## **Rampion 2 Offshore Windfarm – EN010117 SDNPA Further Comments on Deadline 5 Submissions**

SDNPA would like to make the following comments in respect of the Outline Landscape and Ecological Management Plan (LEMP) [REP5-072] and Outline Construction Traffic Management Plan (CTMP) [REP5-068] submitted by the applicant at Deadline 5. It is hoped that these can be taken on board within the final versions of the document.

Rampion 2 Offshore Wind Farm
Access, Rights of way and Streets Plan
Sheet 07

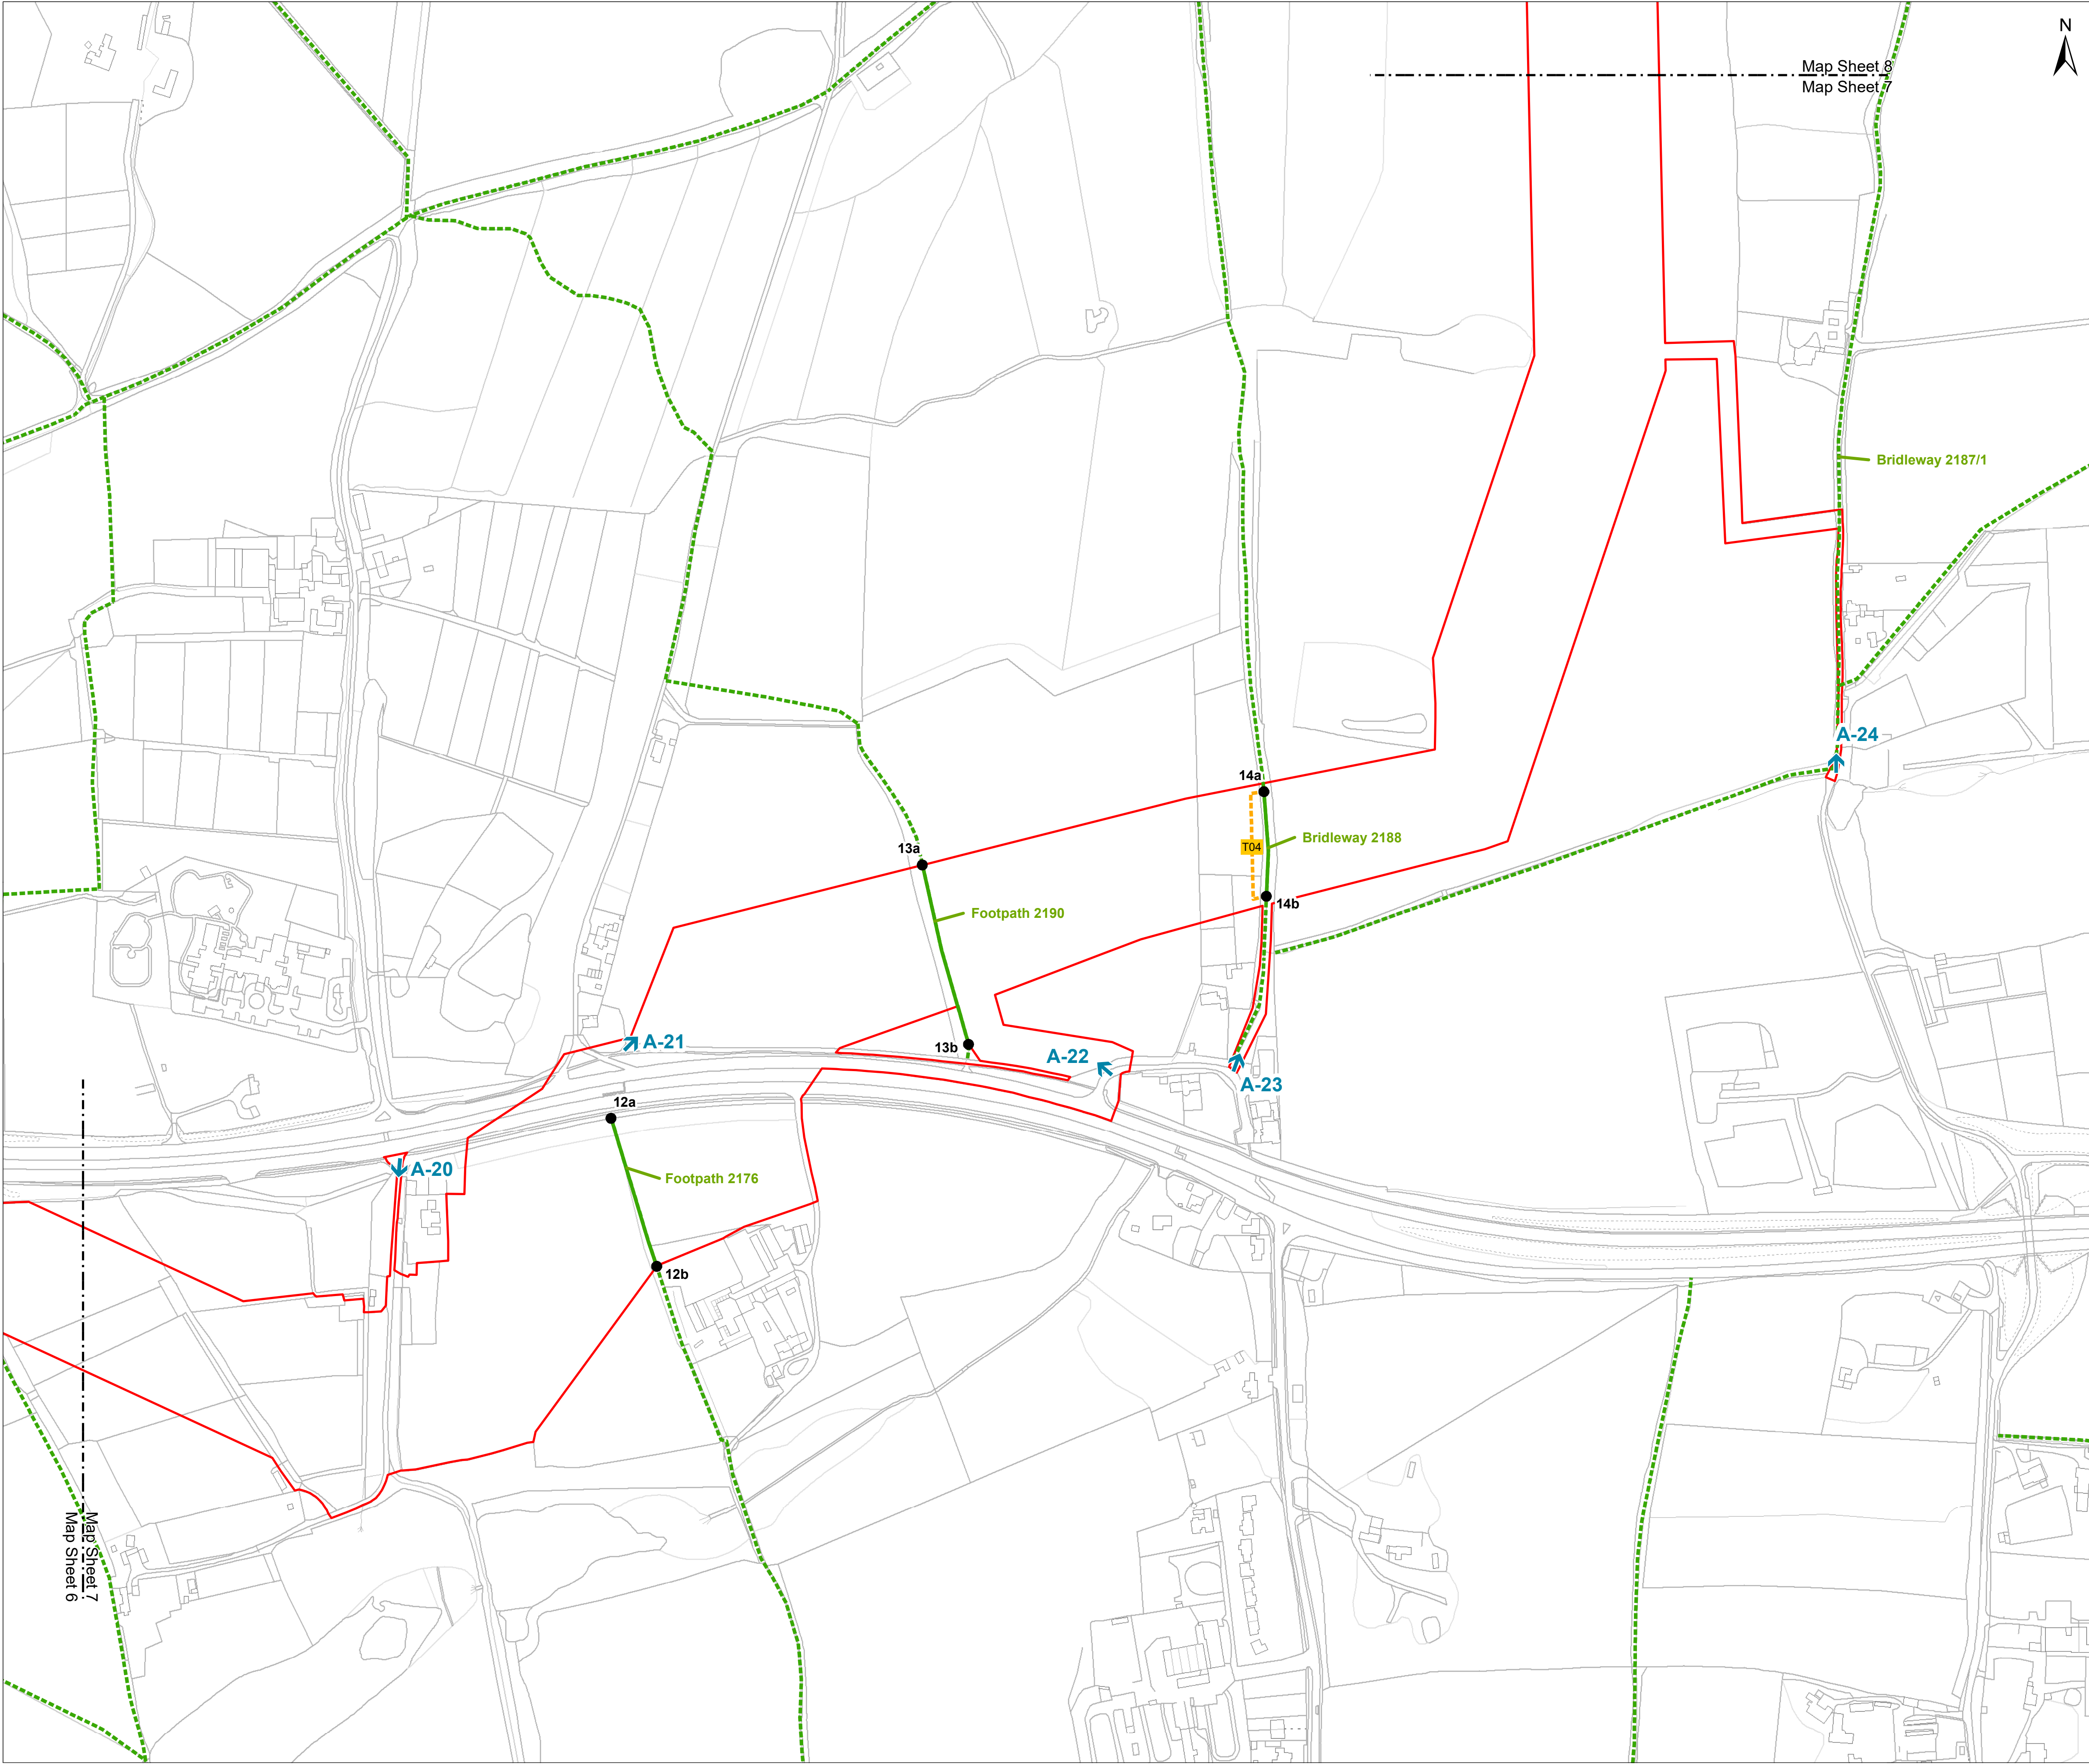
- 2.5 In Appendix A (Access Proposals) A-24 is still included, however SDNPA understood this was to be removed following Issue Specific Hearing 2.
- 2.6 SDNPA query the need for A-27 as an operational access, given A-26 is also noted to be for construction and operational purposes and is only 250m from A-27.
